CITY OF ALBUQUERQUE

Re: Car Wash
7201 Wyoming Blvd NE 87109
Traffic Circulation Layout
Engineer's/Architect's Stamp **06-25-2019 (D19D005)**

Based upon the information provided in your submittal received 07-10-19, the above referenced plan cannot be approved for Building Permit until the following comments are addressed:

SITE PLAN

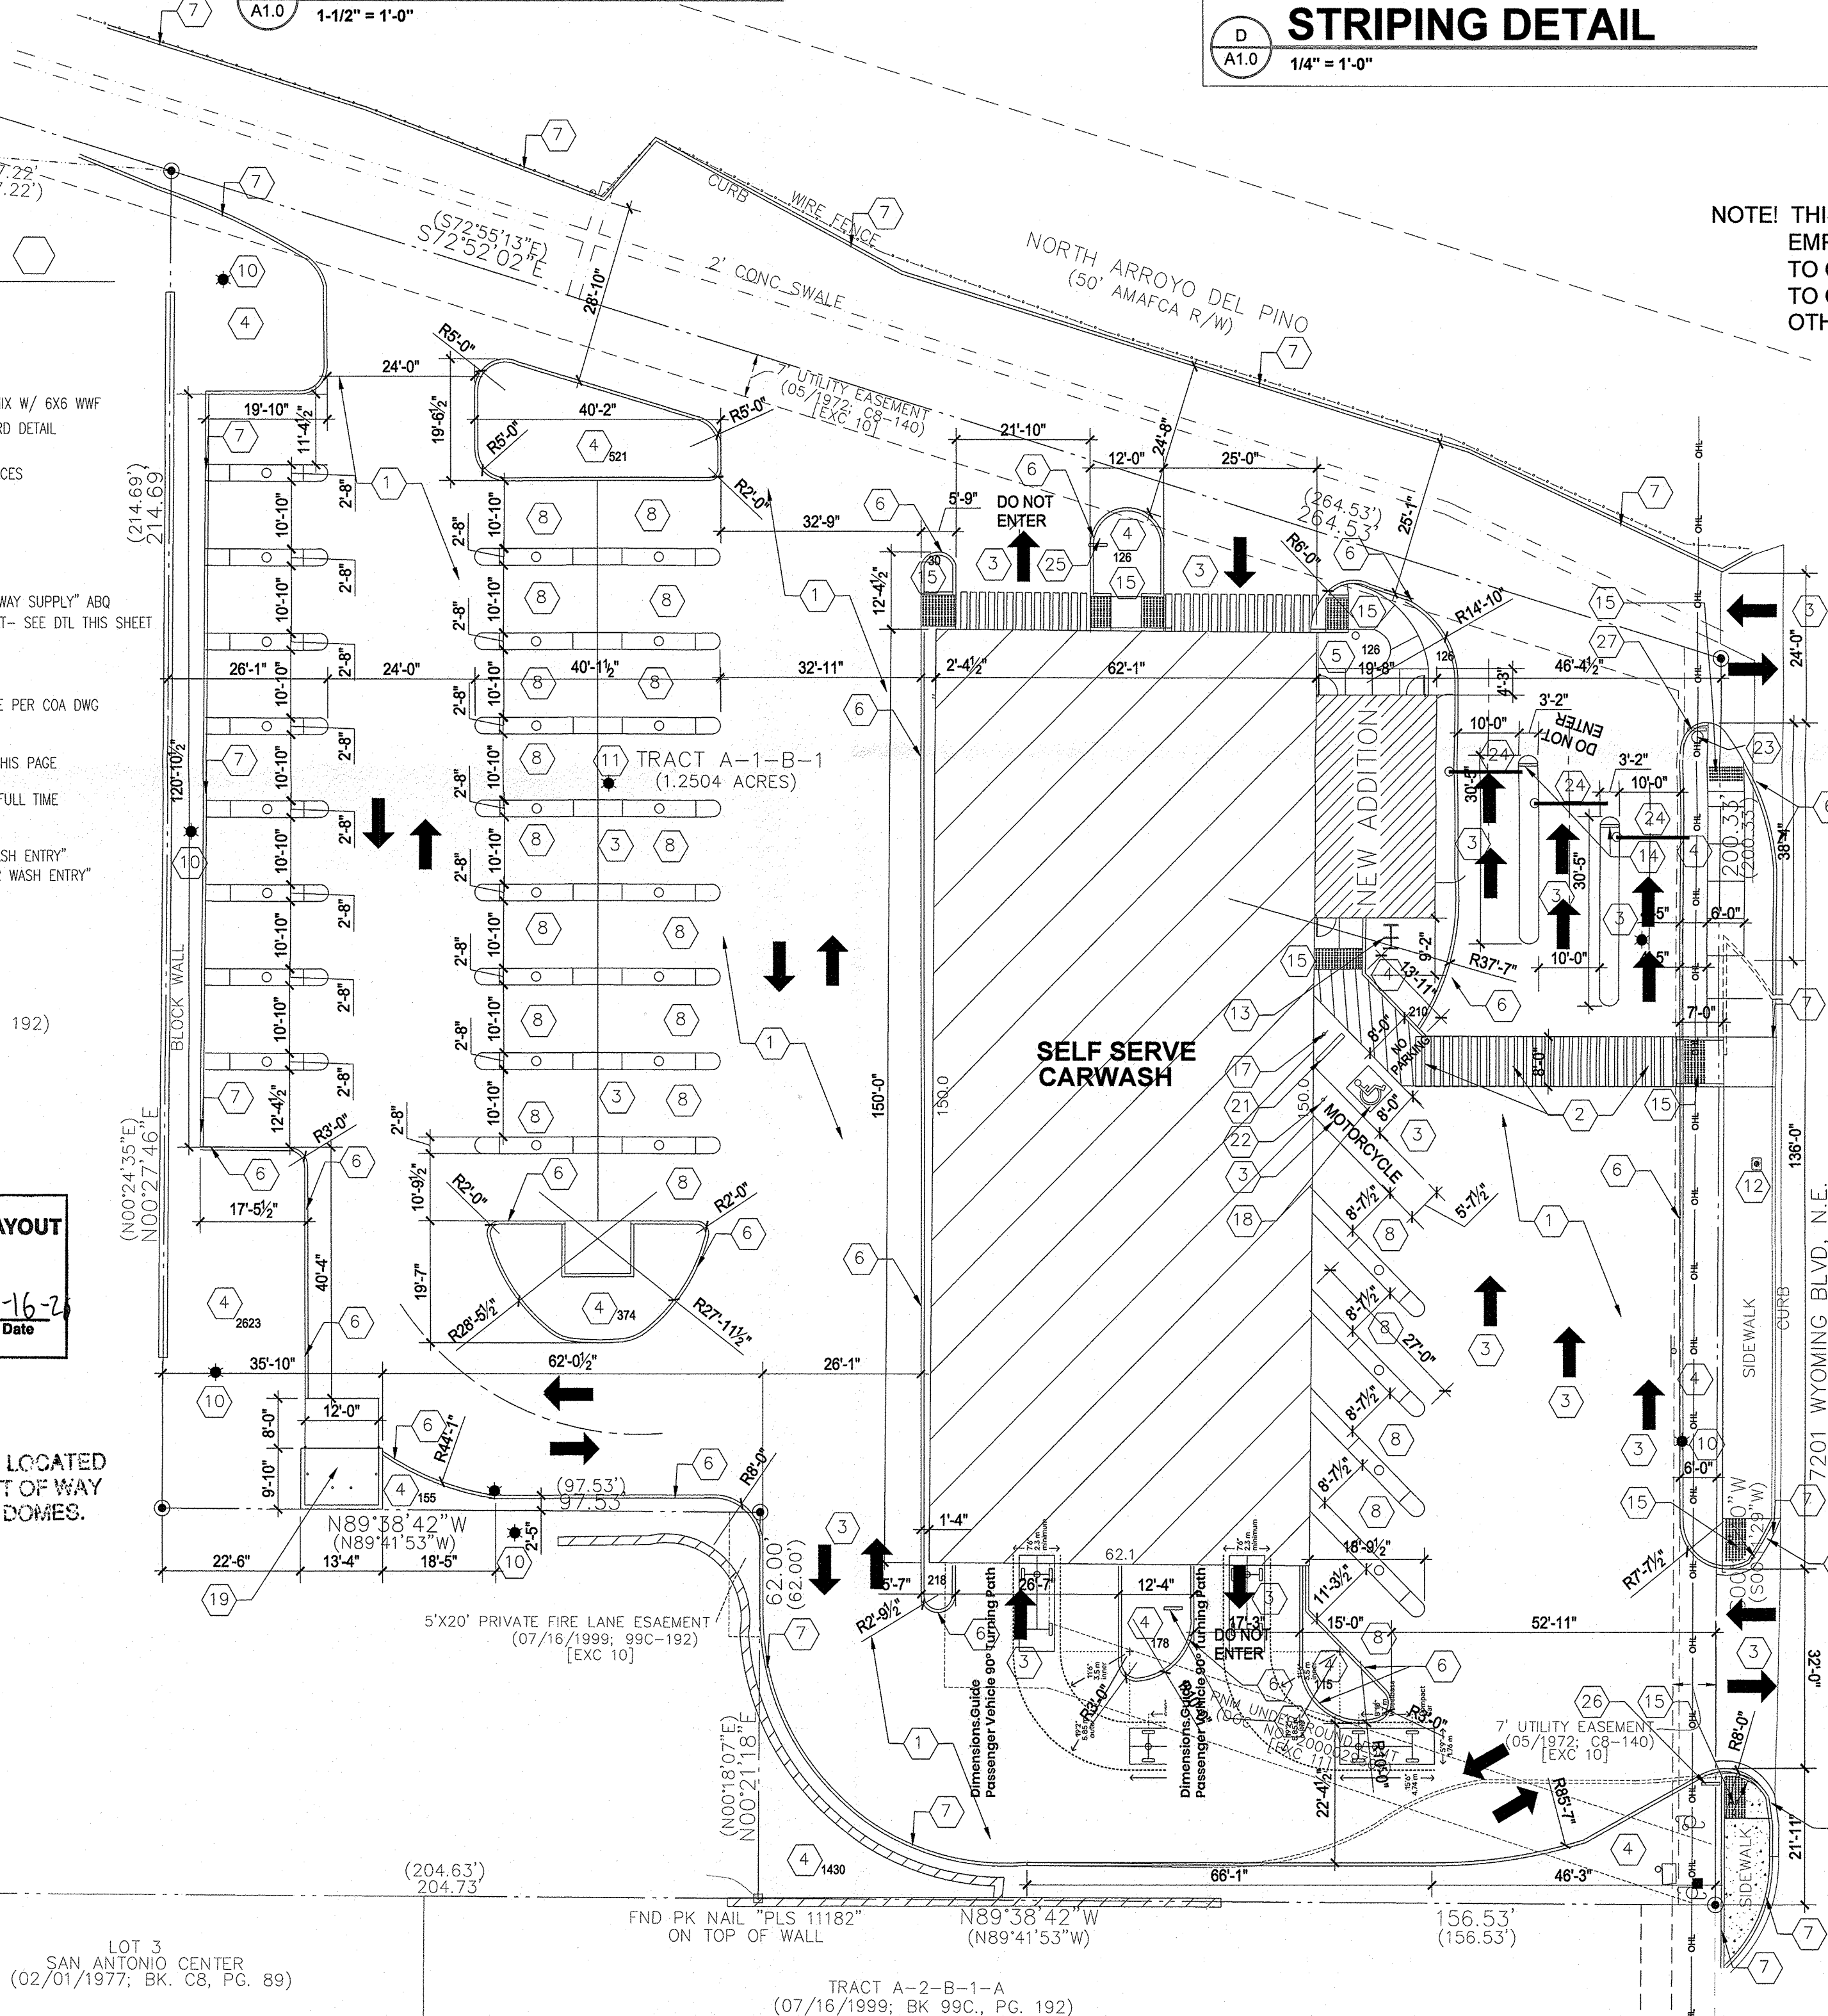
1. Please call out that the ADA accessible parking sign must have the required language per 66-7-352.4C NMSA 1978 **"Violators Are Subject to a Fine and/or Towing."**
2. ADA curb ramps must be updated to current standards and have truncated domes installed.
3. Motorcycle parking spaces shall be designated by its own conspicuously posted upright sign, either free-standing or wall mounted per the zoning code.
4. Bicycle Parking should be in the form of a corral or other vertical feature that clearly demarcates the space as intended for bicyclist only. Corrals are most appropriate at street corners.
5. provide a copy of refuse approval.
6. Add adequate "do not enter sign" at the right locations.
7. The proposed new curb #6: match this curb with the existing curb and continue along the redline as shown:

8. Please provide a turning template for this area:
